Consultation Response from KC, Lead Local Flood Authority
2023/93236 Pentlands, New Mill Road, Holmfirth, HD9 7LN
Discharge conditions 4 (Internal Estate Road Details), 5 (Parking Bay Surfacing & Drainage), 9 (Temporary Waste Measures), 11 (Surface Water Drainage Details), 12 (Overflow Event Scenario), 13 (Separate Forms of Drainage Details), 15 (Temporary Drainage Measures), 22 (Ecological Enhancement Plan) on previous permission 2020/91896 for demolition of existing dwelling and erection of 15 dwellings with associated access and external works
Date Responded: 12th March 2024 Responding Officer: Paul Farndale Responding Ref:

Condition 11 – Drainage Details

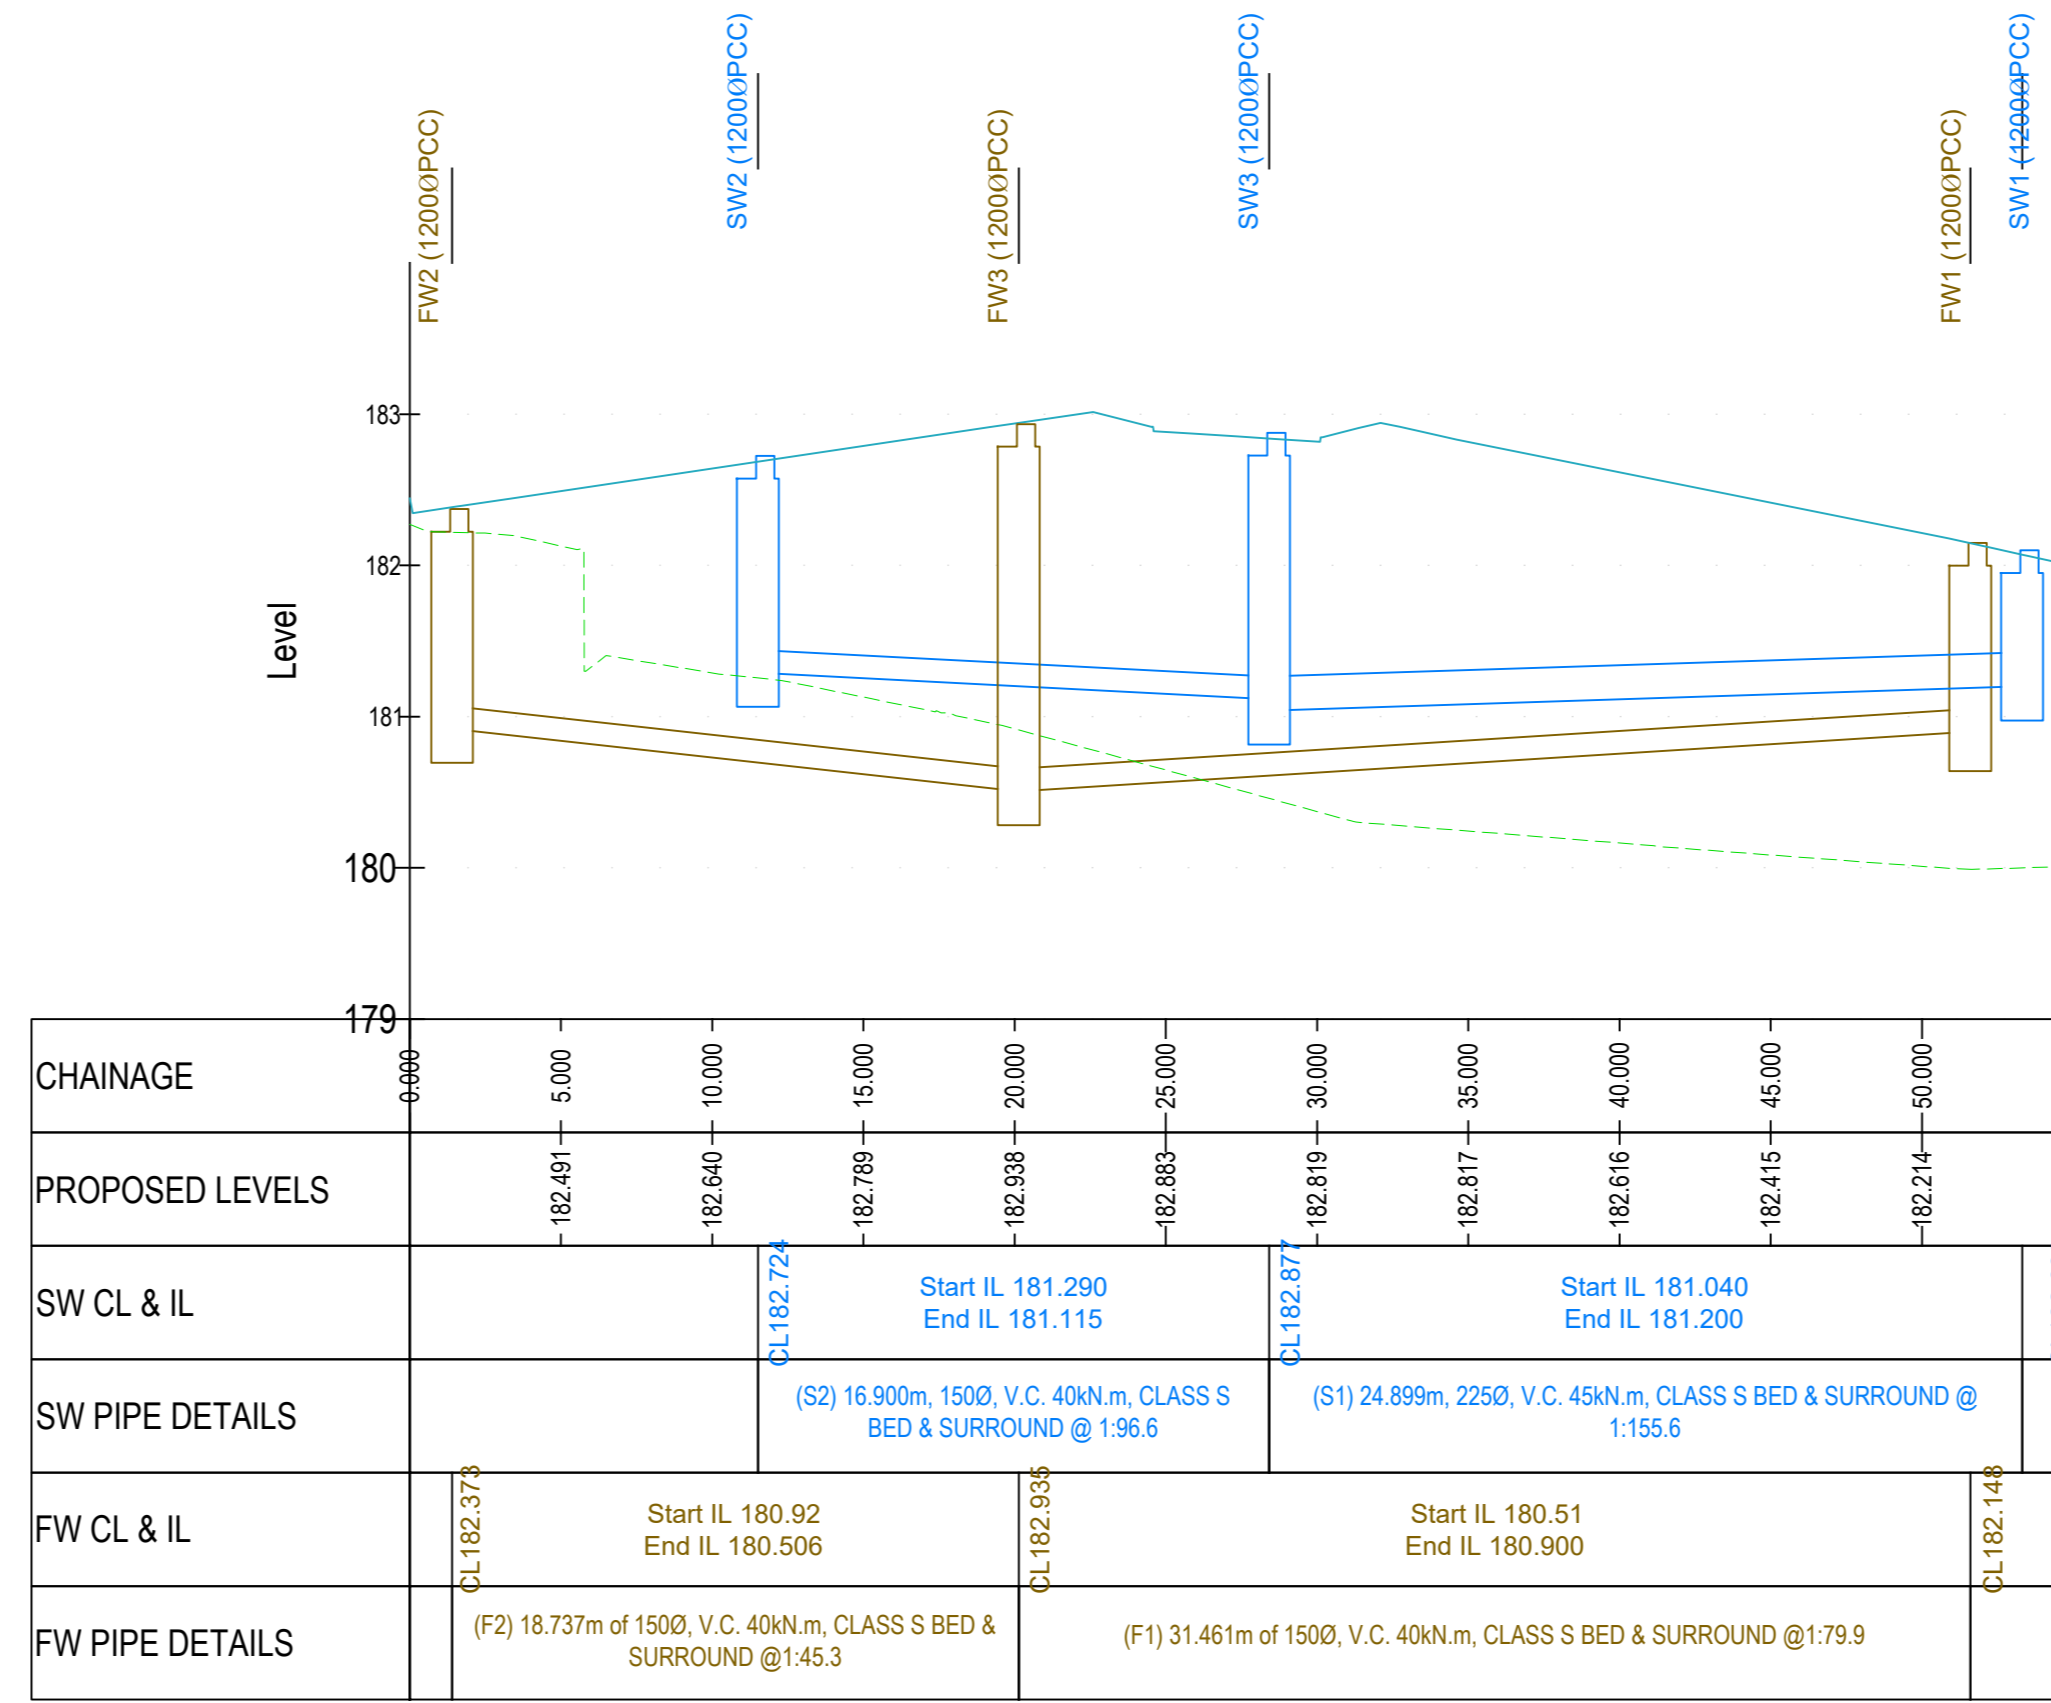
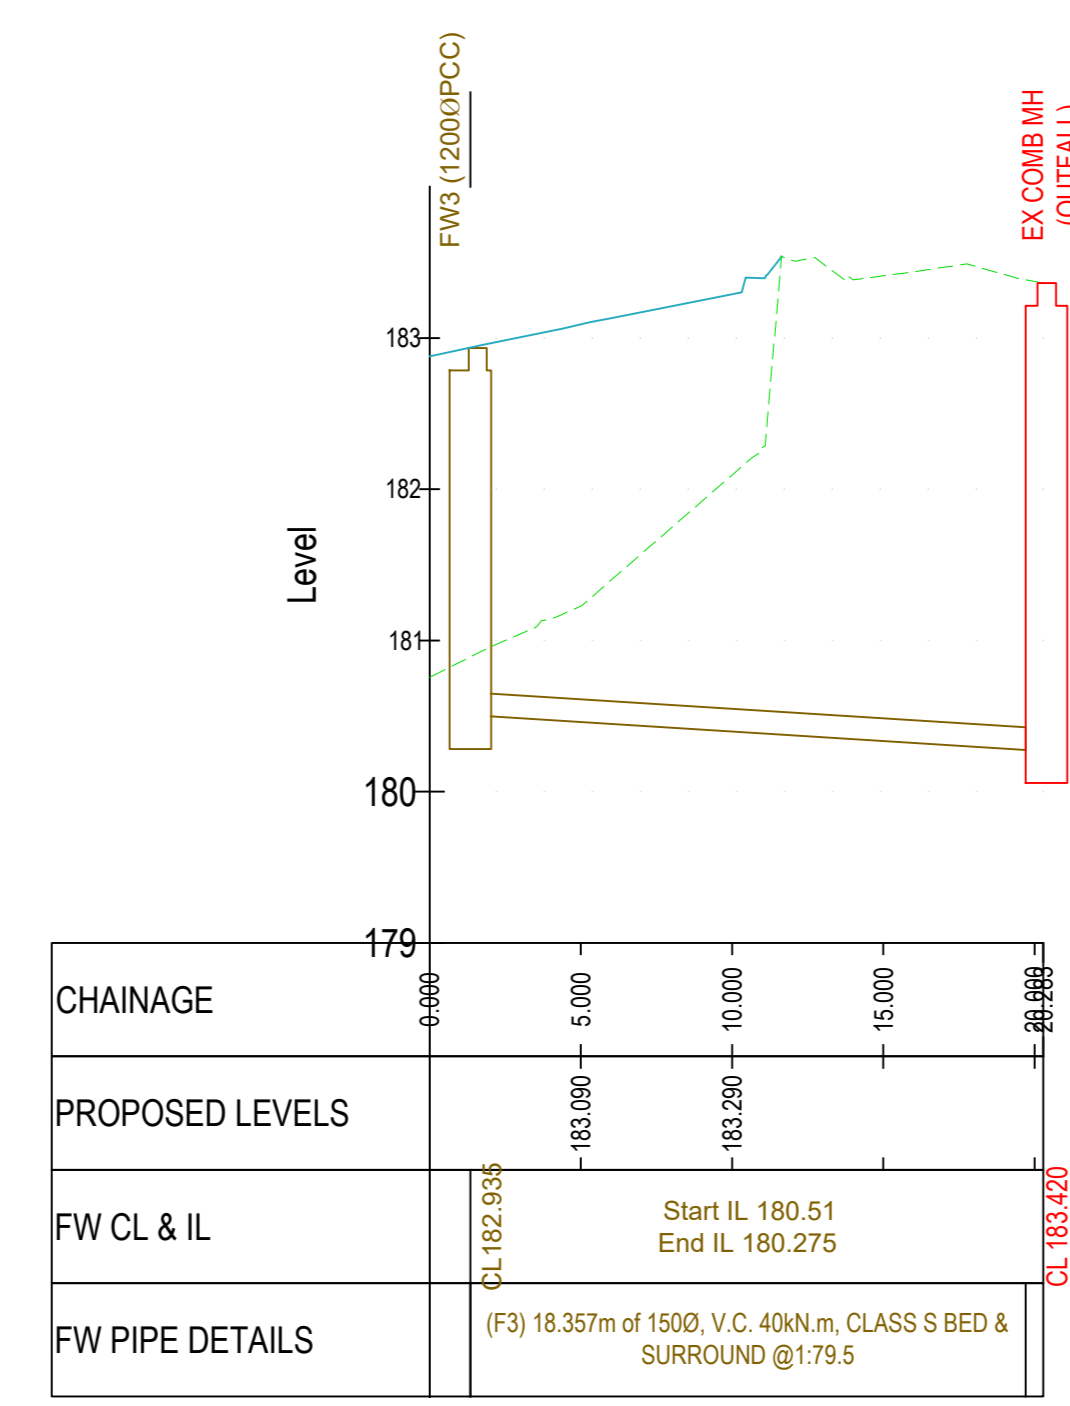
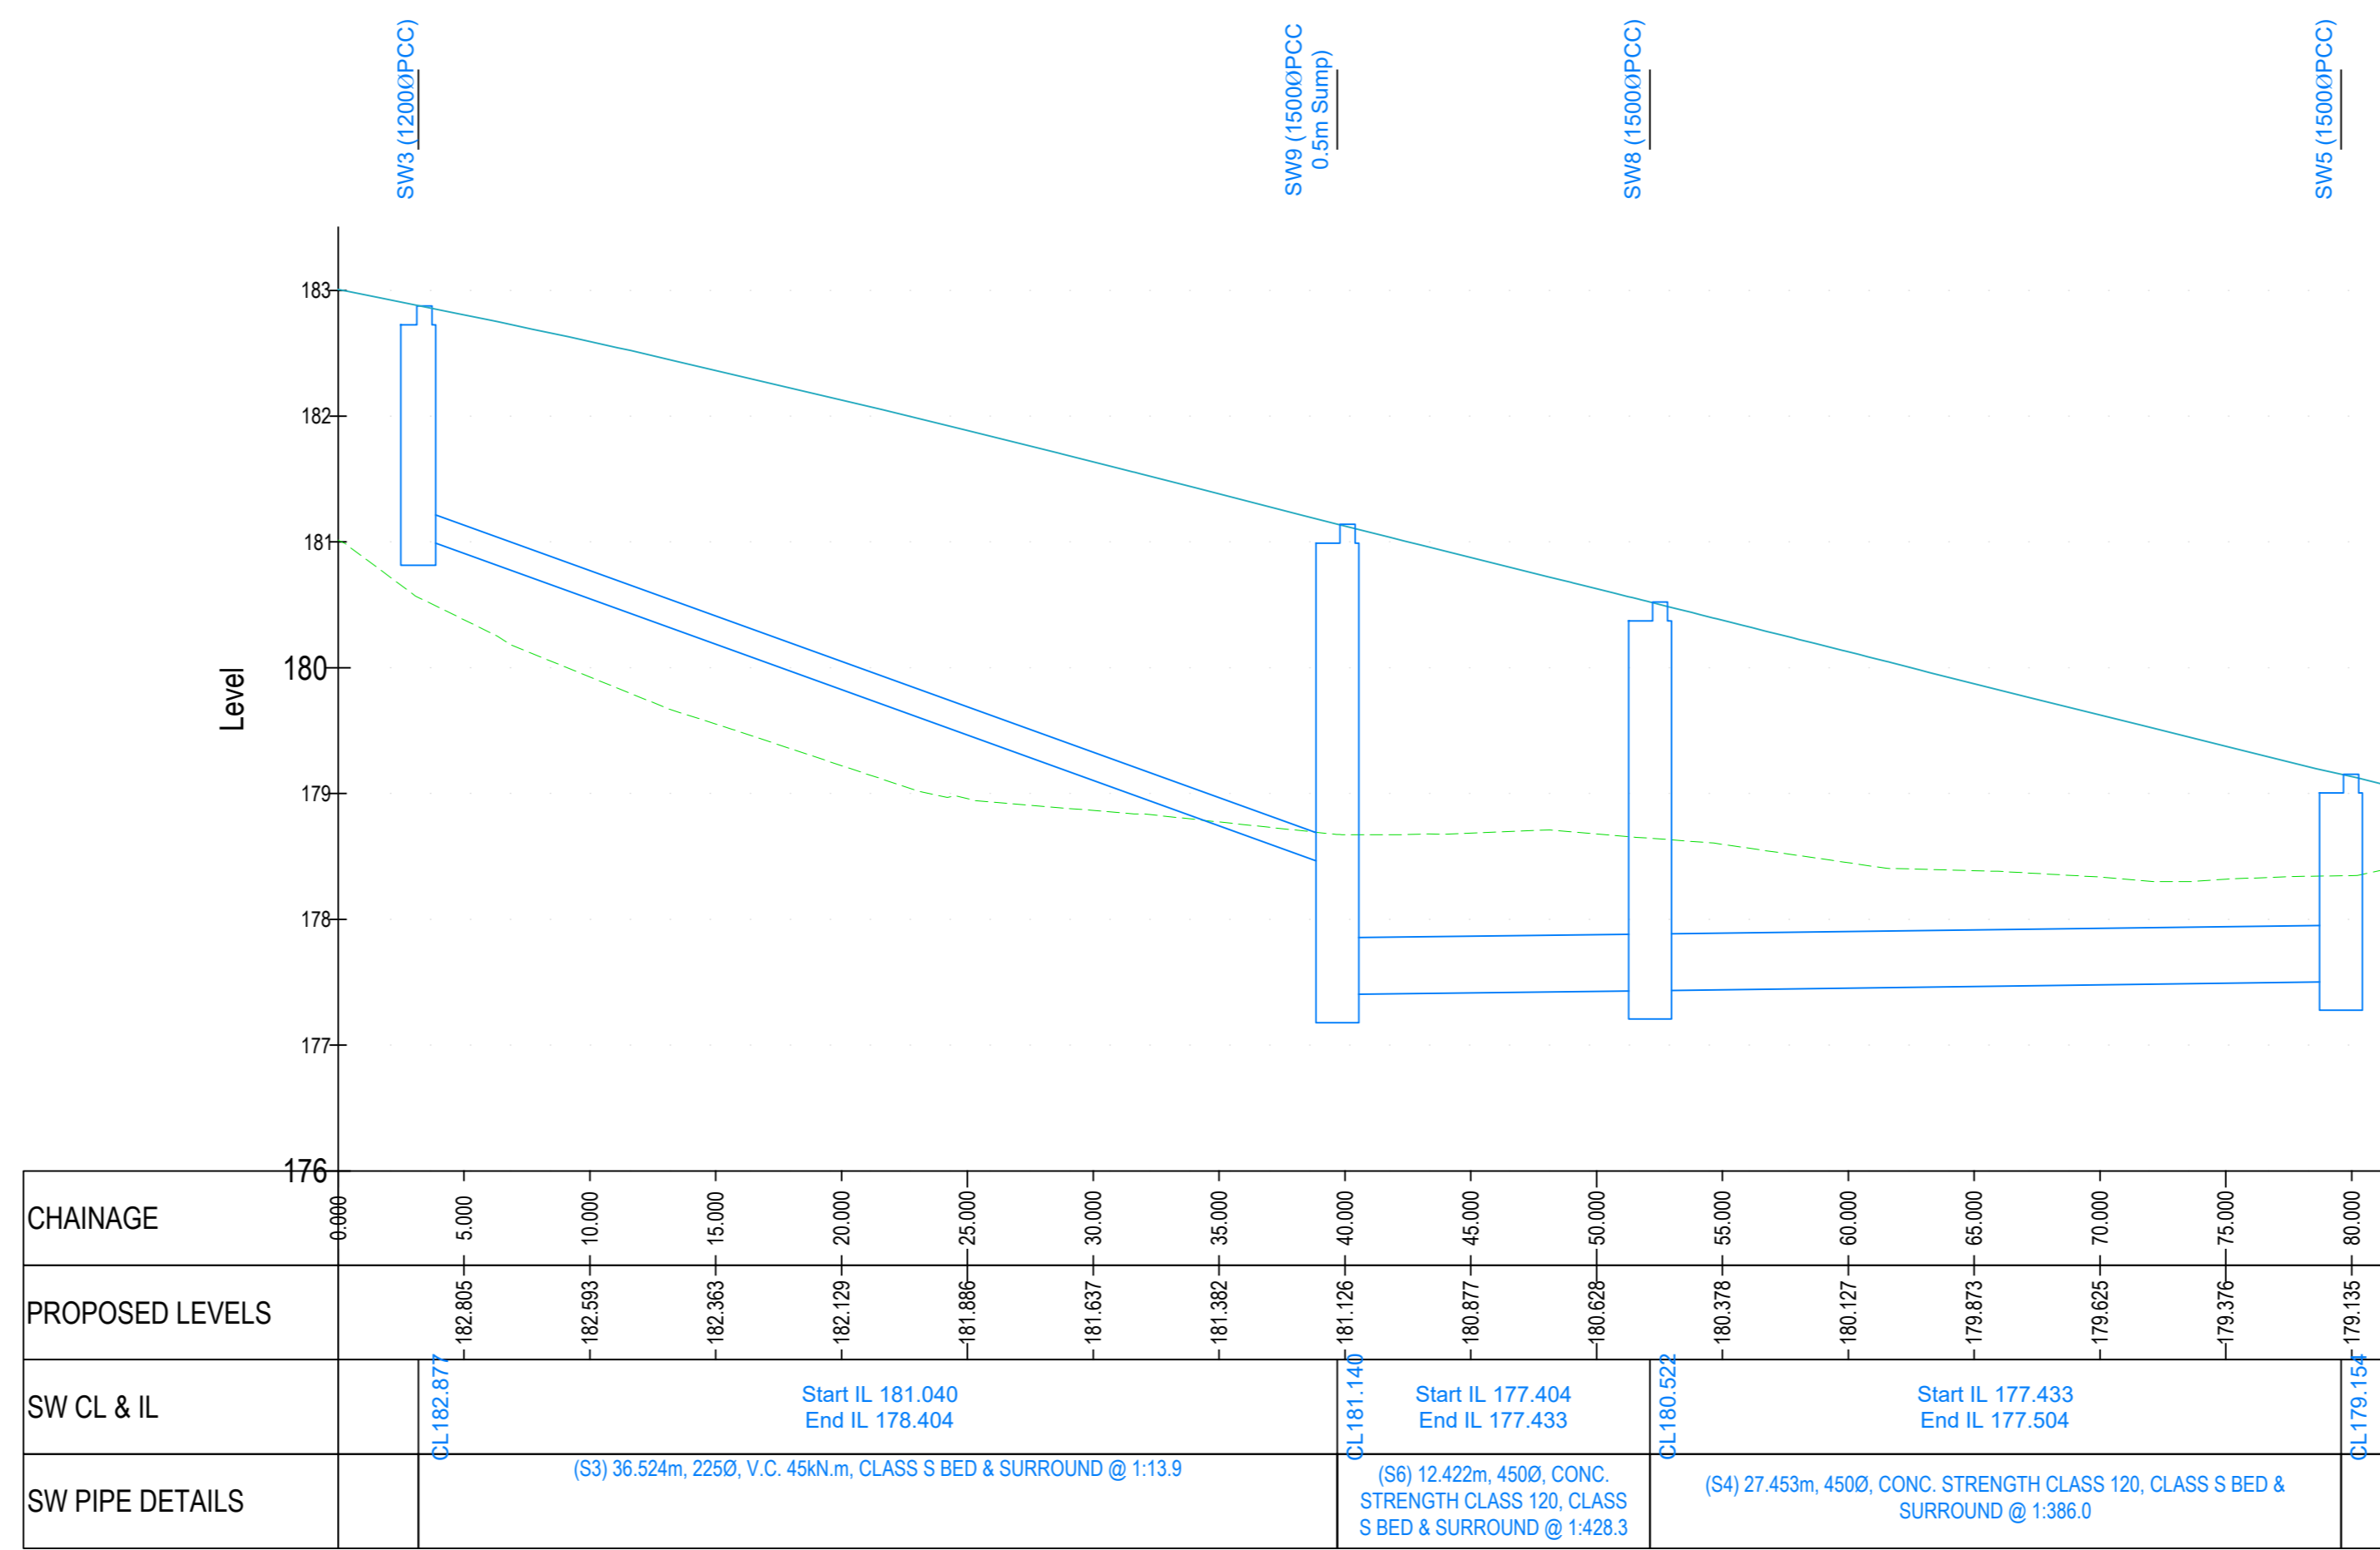
Off-site works are now shown with longitudinal sections. The adjacent site has a temporary outfall and therefore the connection can be made.
